Planning Application NO - 3/2026/0256
Grid Ref 372710 436972.

Re: Planning Application No: 3/2026/0256 – Objection to change of use of a dwelling house (C3) to a children's home (C2)

Opposition to The Planning Application for proposed change of use of 36, Moor Field, Whalley, BB7 9SA from a dwelling house (Use Class C3) to a children's home (use Class C2) for up to 2 young people between the age of 8 and up to 18.

Application No: 3/2026/0256
Proposed change of use of a dwelling house to a children's home
36 Moor Field, Whalley BB7 9SA

Figure 2: NB25_18-03D pr plans 50-A1

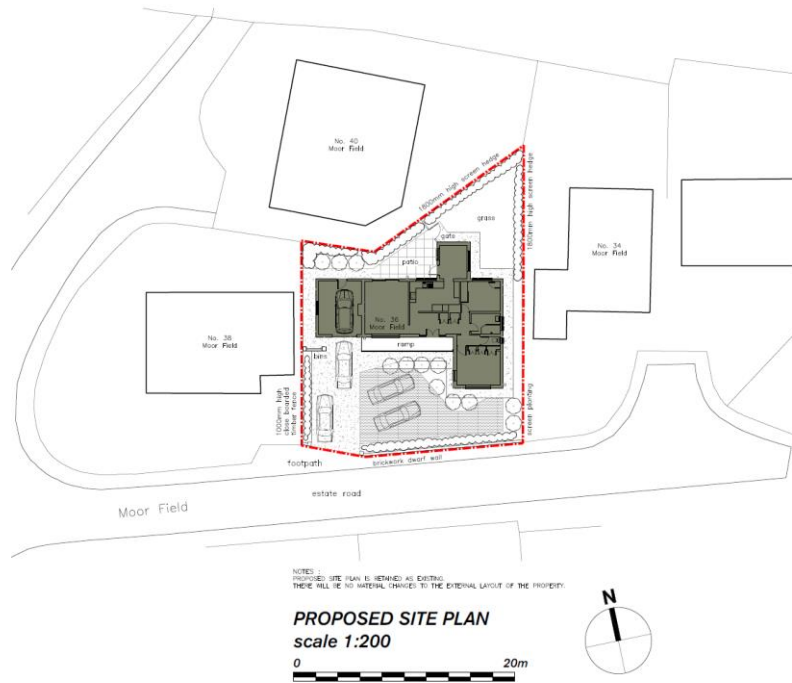
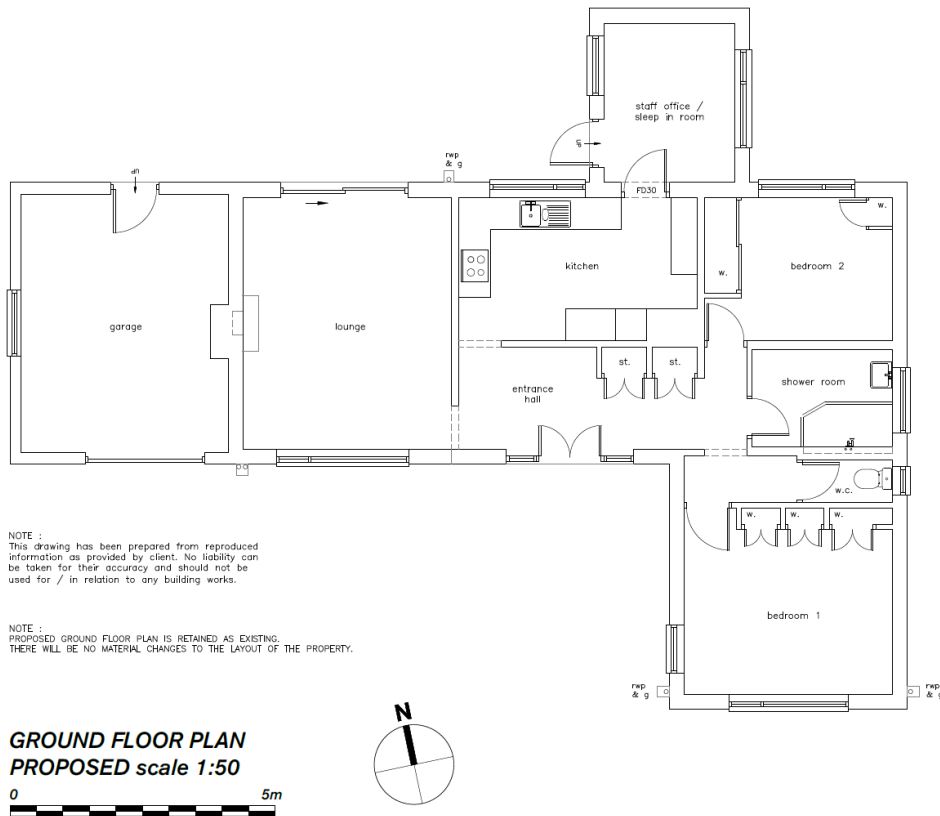
Parking issues will continue despite changes to the front garden to accommodate 4 cars. Not all the parked cars will be able to enter/exit the drive uninhibited, at least 1 car will have to be moved to allow others to manoeuvre.

The small dining room which is off the kitchen and accommodates the back door, has been identified as an office/bedroom for staff. Is there a suggested minimum standard for sleeping accommodation for staff who sleep in?

- The application states that there is parking for 4 cars in front of the property. Whilst this is strictly correct, it has been very poorly provided by removing the whole of the front garden and replacing with tarmac. I very much doubt that there is enough space for cars to leave the drive when 4 cars are parked which will result in endless shunting of vehicles particularly at shift handover times. Or as human nature will undoubtedly prevail, many more vehicles will be parked in the cul-de-sac

- The creation of the parking space by removal of all the front garden area has left the bungalow with only a small area of green space at the rear not the "large Garden" referred to in the application and insufficient for children to play in

1. The title deeds for properties within Moor Field specifically state that they are to be used for a family dwelling house, not for business purposes which this proposal is.
2. The bungalow is situated on a cul-de-sac with a carriageway of 4 m maximum width. Private vehicles can traverse the highway but heavy goods vehicles have to mount the footpath in certain circumstances.
3. With the above in mind, visitors to the property, be it staff, relatives, professionals, deliveries etc would create chaos impacting the neighbourhood and create animosity with the residents.
4. Carparking spaces have been provided by destroying the front garden which has already created bad feeling, and the layout only provides for a free for all at all hours. Extended, the drive can barely cater for more than 2 cars. Who would police the changeover when staff alternate?
